Subject: RE: Development at Ferringham lane - FG/145/21/DOC

Re: Development at Ferringham lane - FG/145/21/DOC

Engineers Comments Regarding Surface Water Drainage

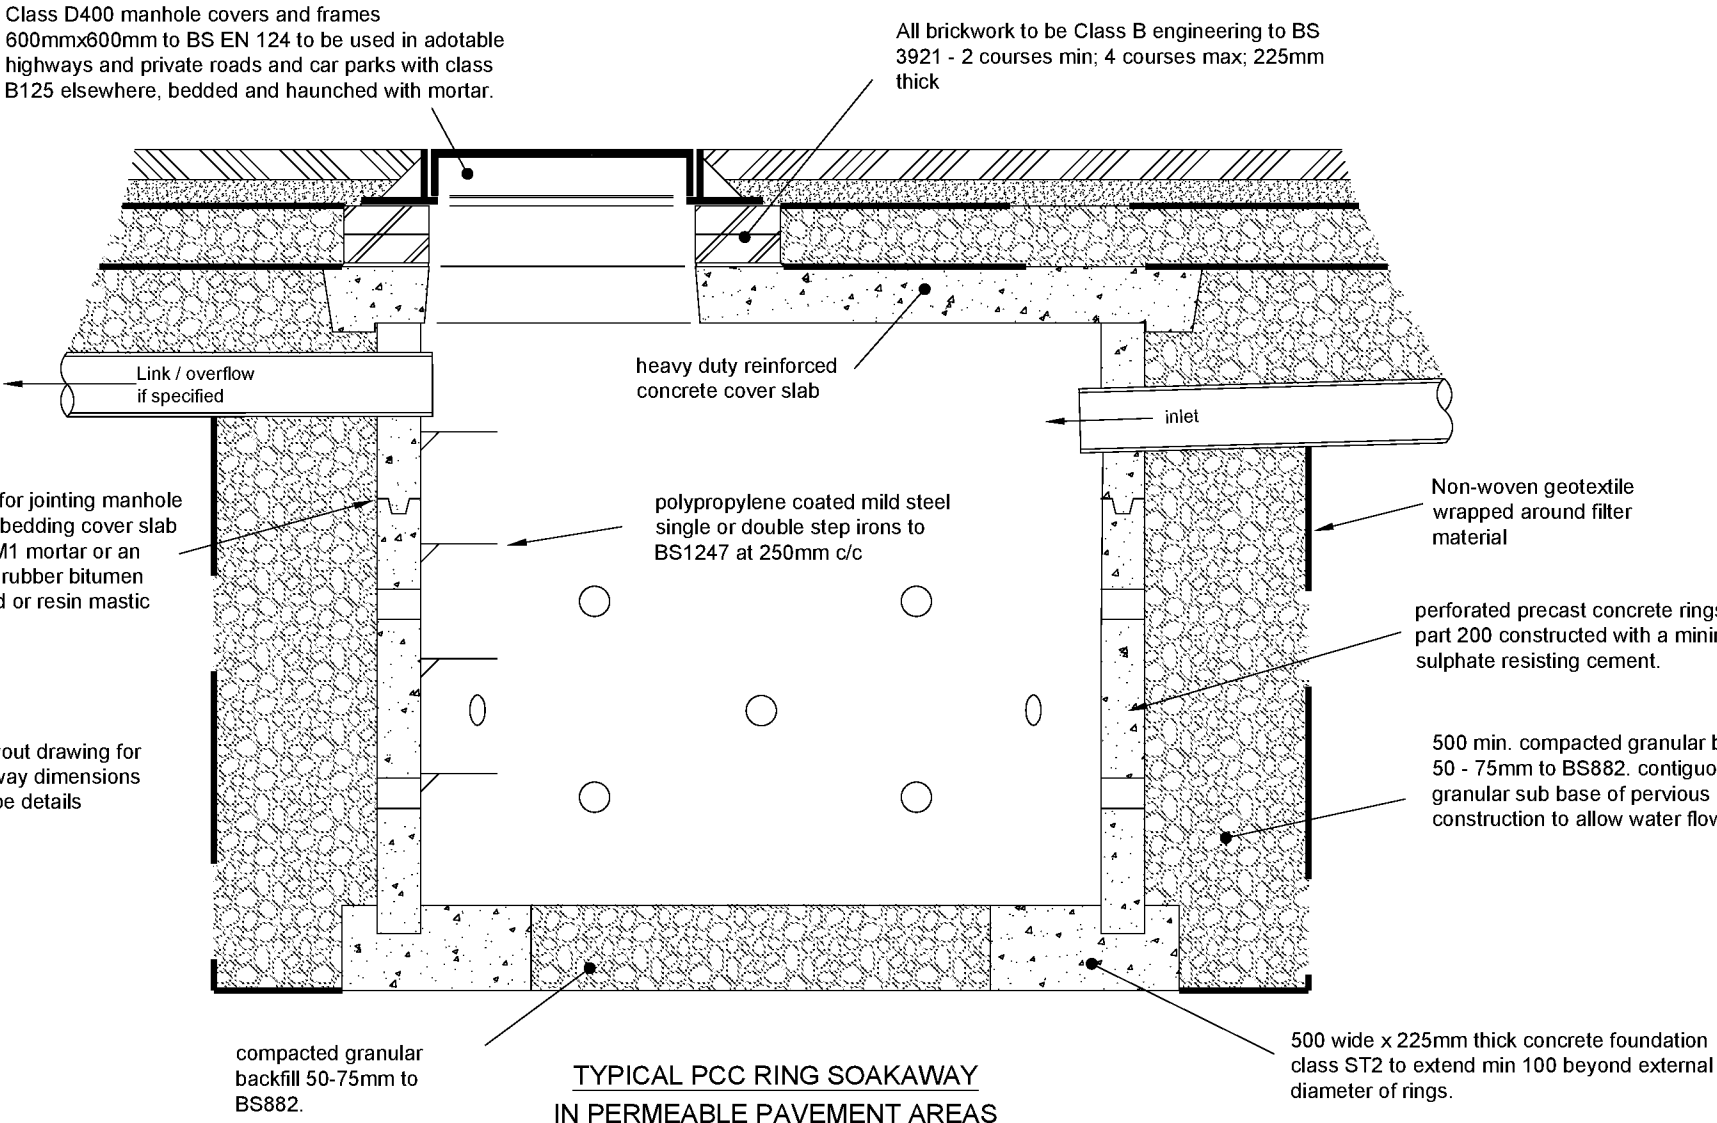
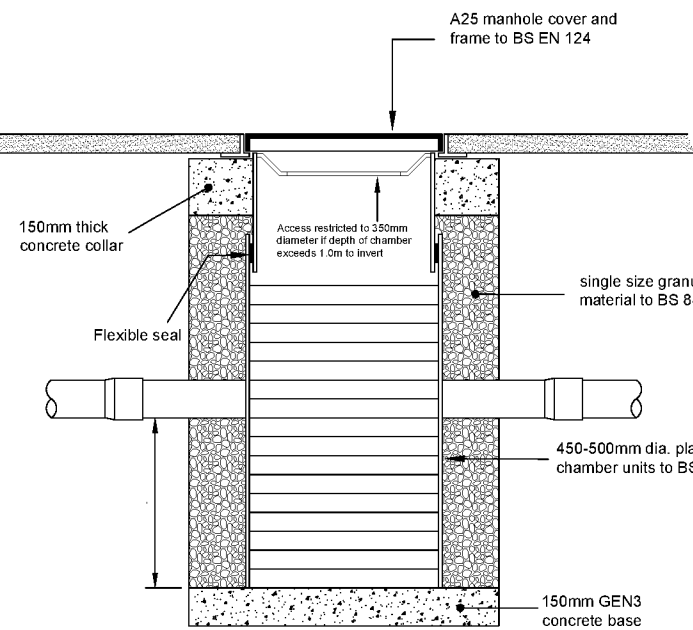
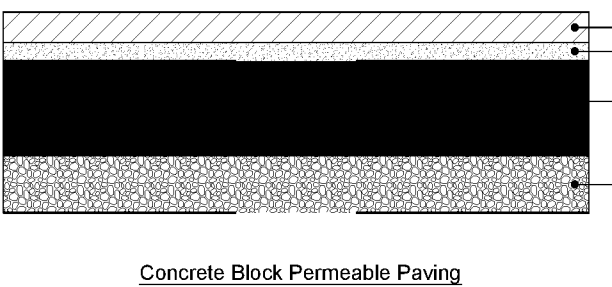
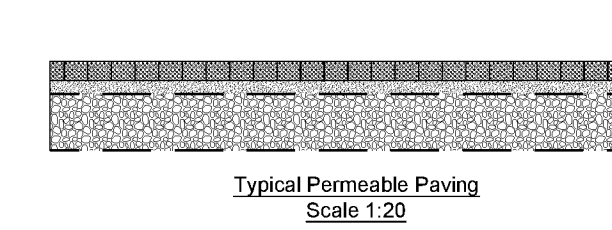
4. *The Drainage Layout needs to be updated to account for the updated layout. Please pay attention to Note 10 on our Drainage Checklist [download.cfm \(arun.gov.uk\)](https://www.arun.gov.uk/download.cfm) for the level of detail required on the layout as this will have changed since the previous approval in 2018. I have attached my revised site plan 20-07-3.17*

5. *Please provide construction detail drawings for all components. Again this requirement is listed in the drainage checklist linked above (under Note 11).* On the attached revised site plan 20-07-3.17 Revision E, I have added construction details as shown on the layout previously approved.

Following your recent emails I have attached my revised drawings 20-07-3.17 Revision E. I have added additional information relating to the drainage along with a detail of the bin store to be positioned at the bin collection area and a detail of the new close boarded fencing. The location of new fencing is shown on the landscape plan.

Revision E, on which I have added additional information. I have also omitted the additional soakaways shown in the rear gardens
